Our ref: DOC21/26870
Senders ref: SSD 10425

Response to Submissions – Tallawong Station Precinct South – Stage 2 Detailed Design Modification Application 1 (SSD 10425)

FIGURE D7 FLOOD LEVEL DIFFERENCE – PMF

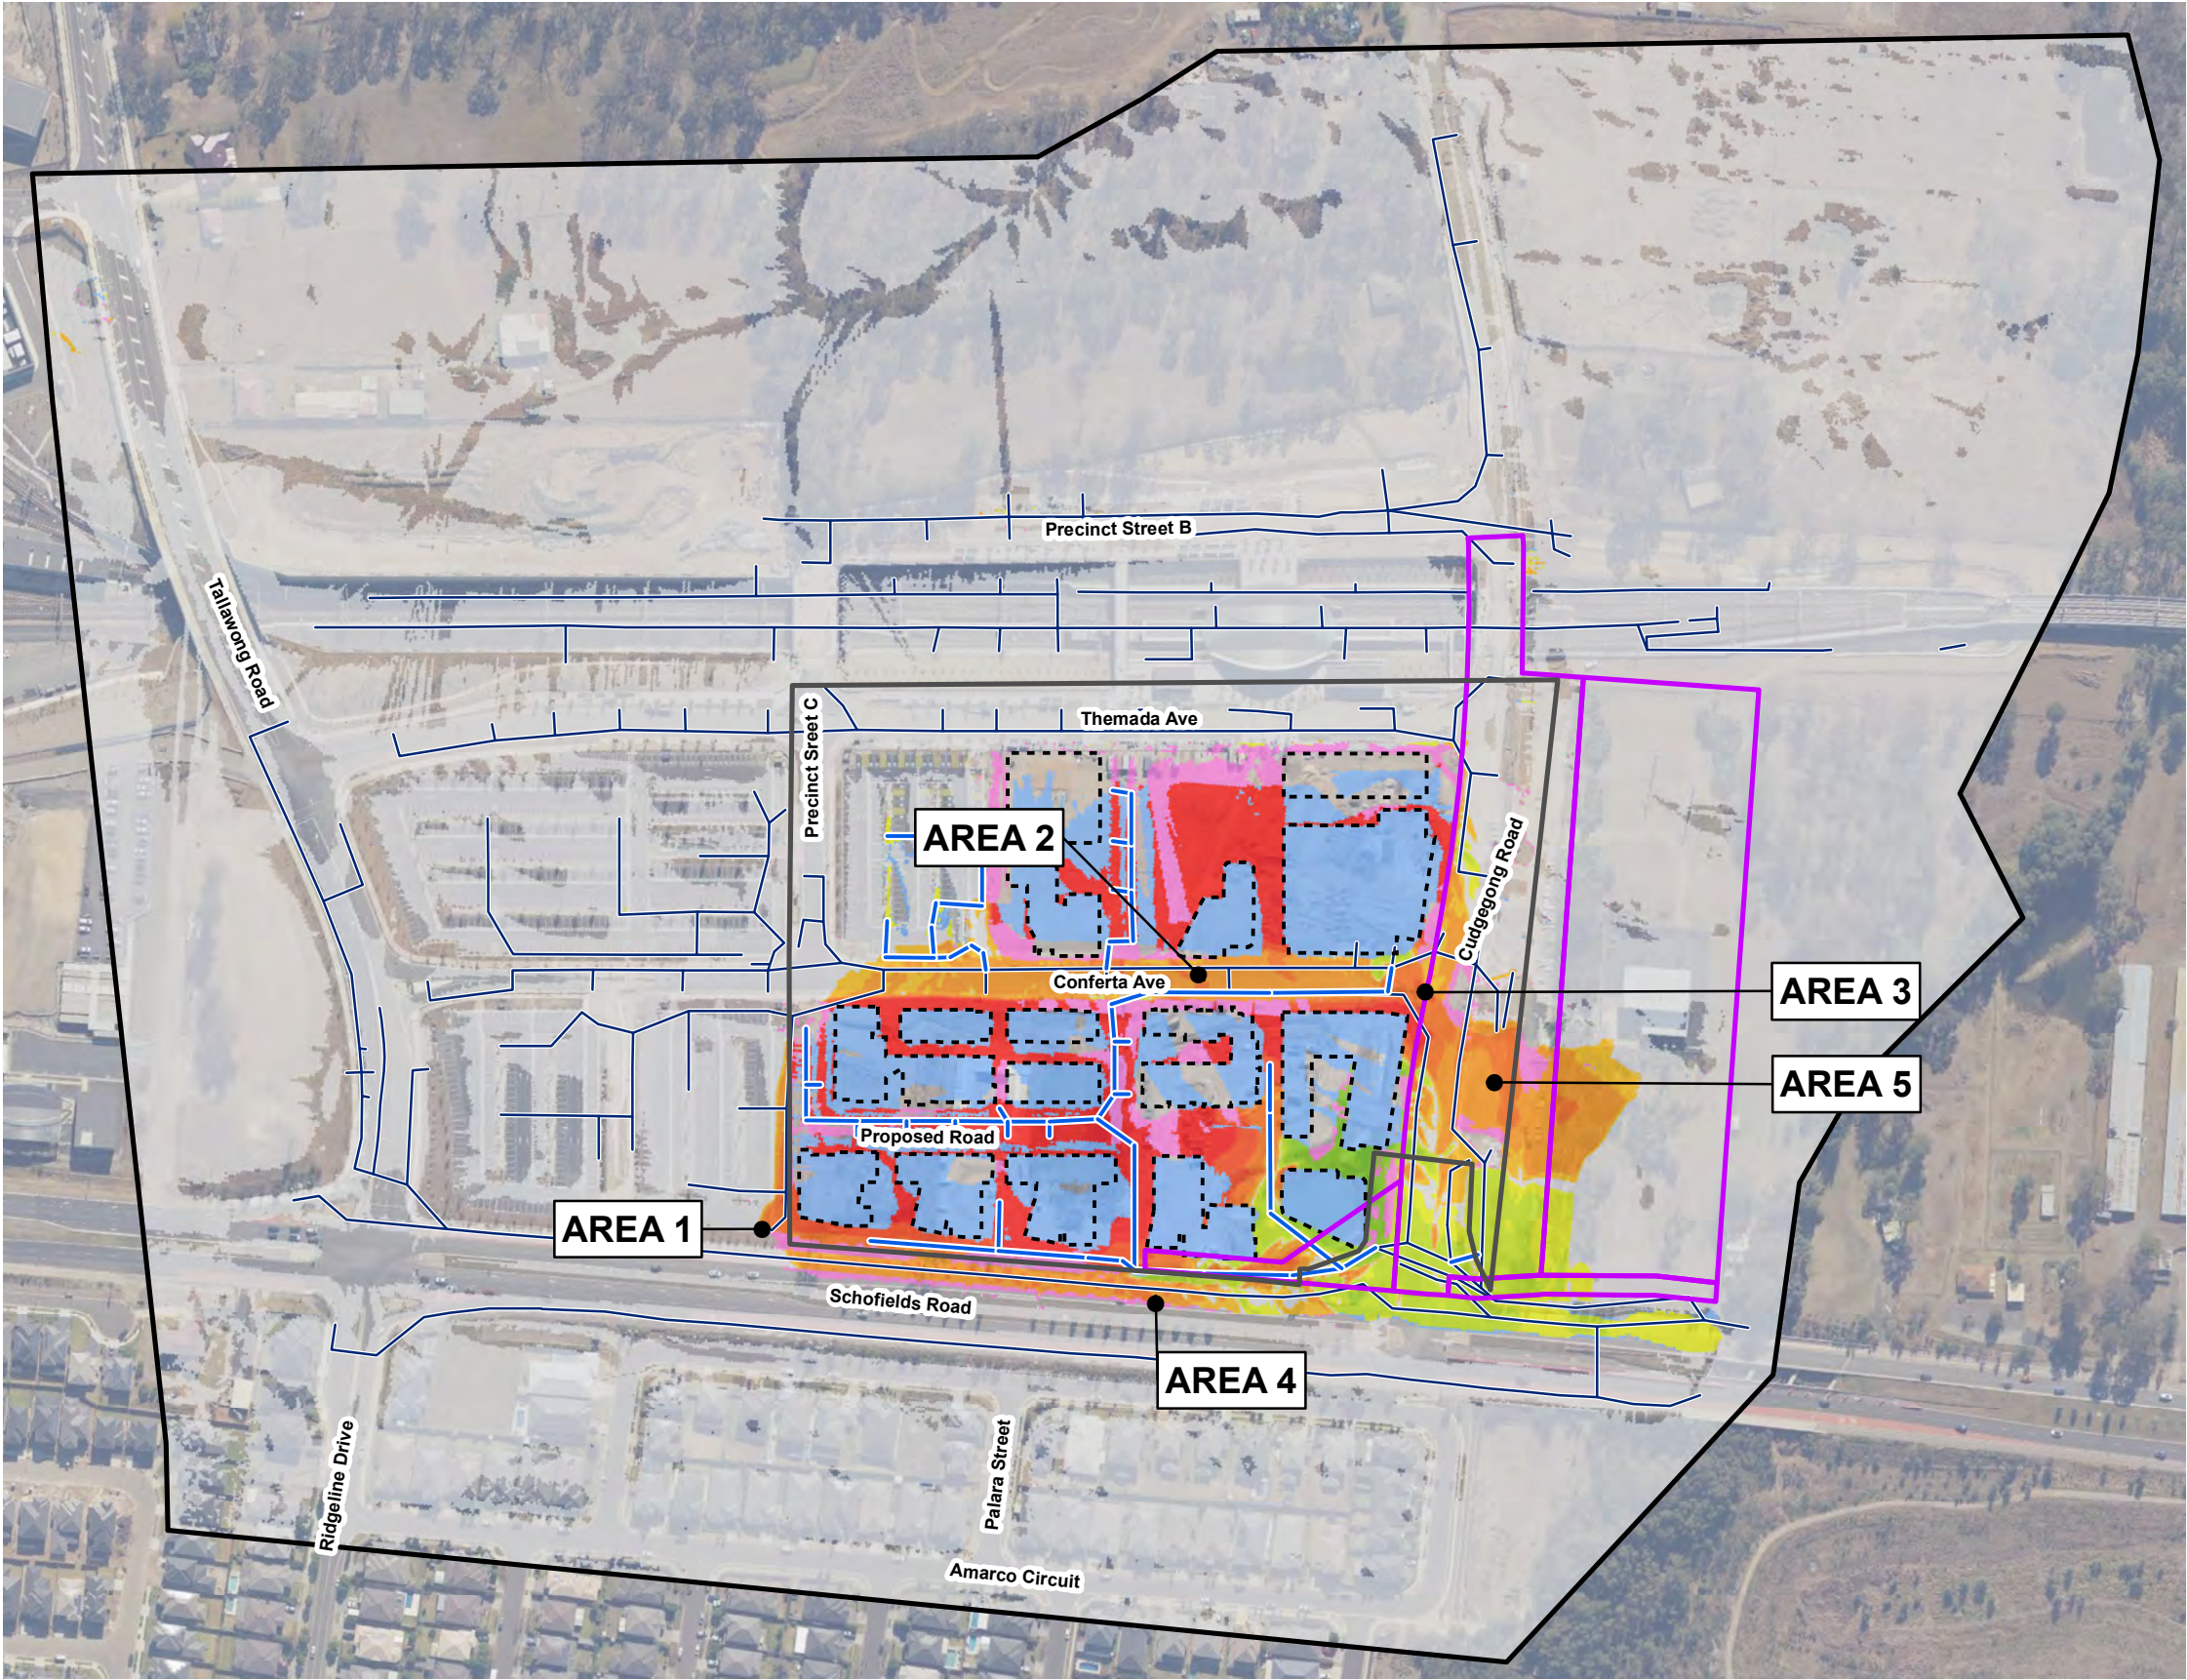
- The flood level difference maps need careful review as they show some discrepancies particularly at the southern corner of Cudgegong Road. The difference maps show reduction instead of increase in levels at this area for all flood events.
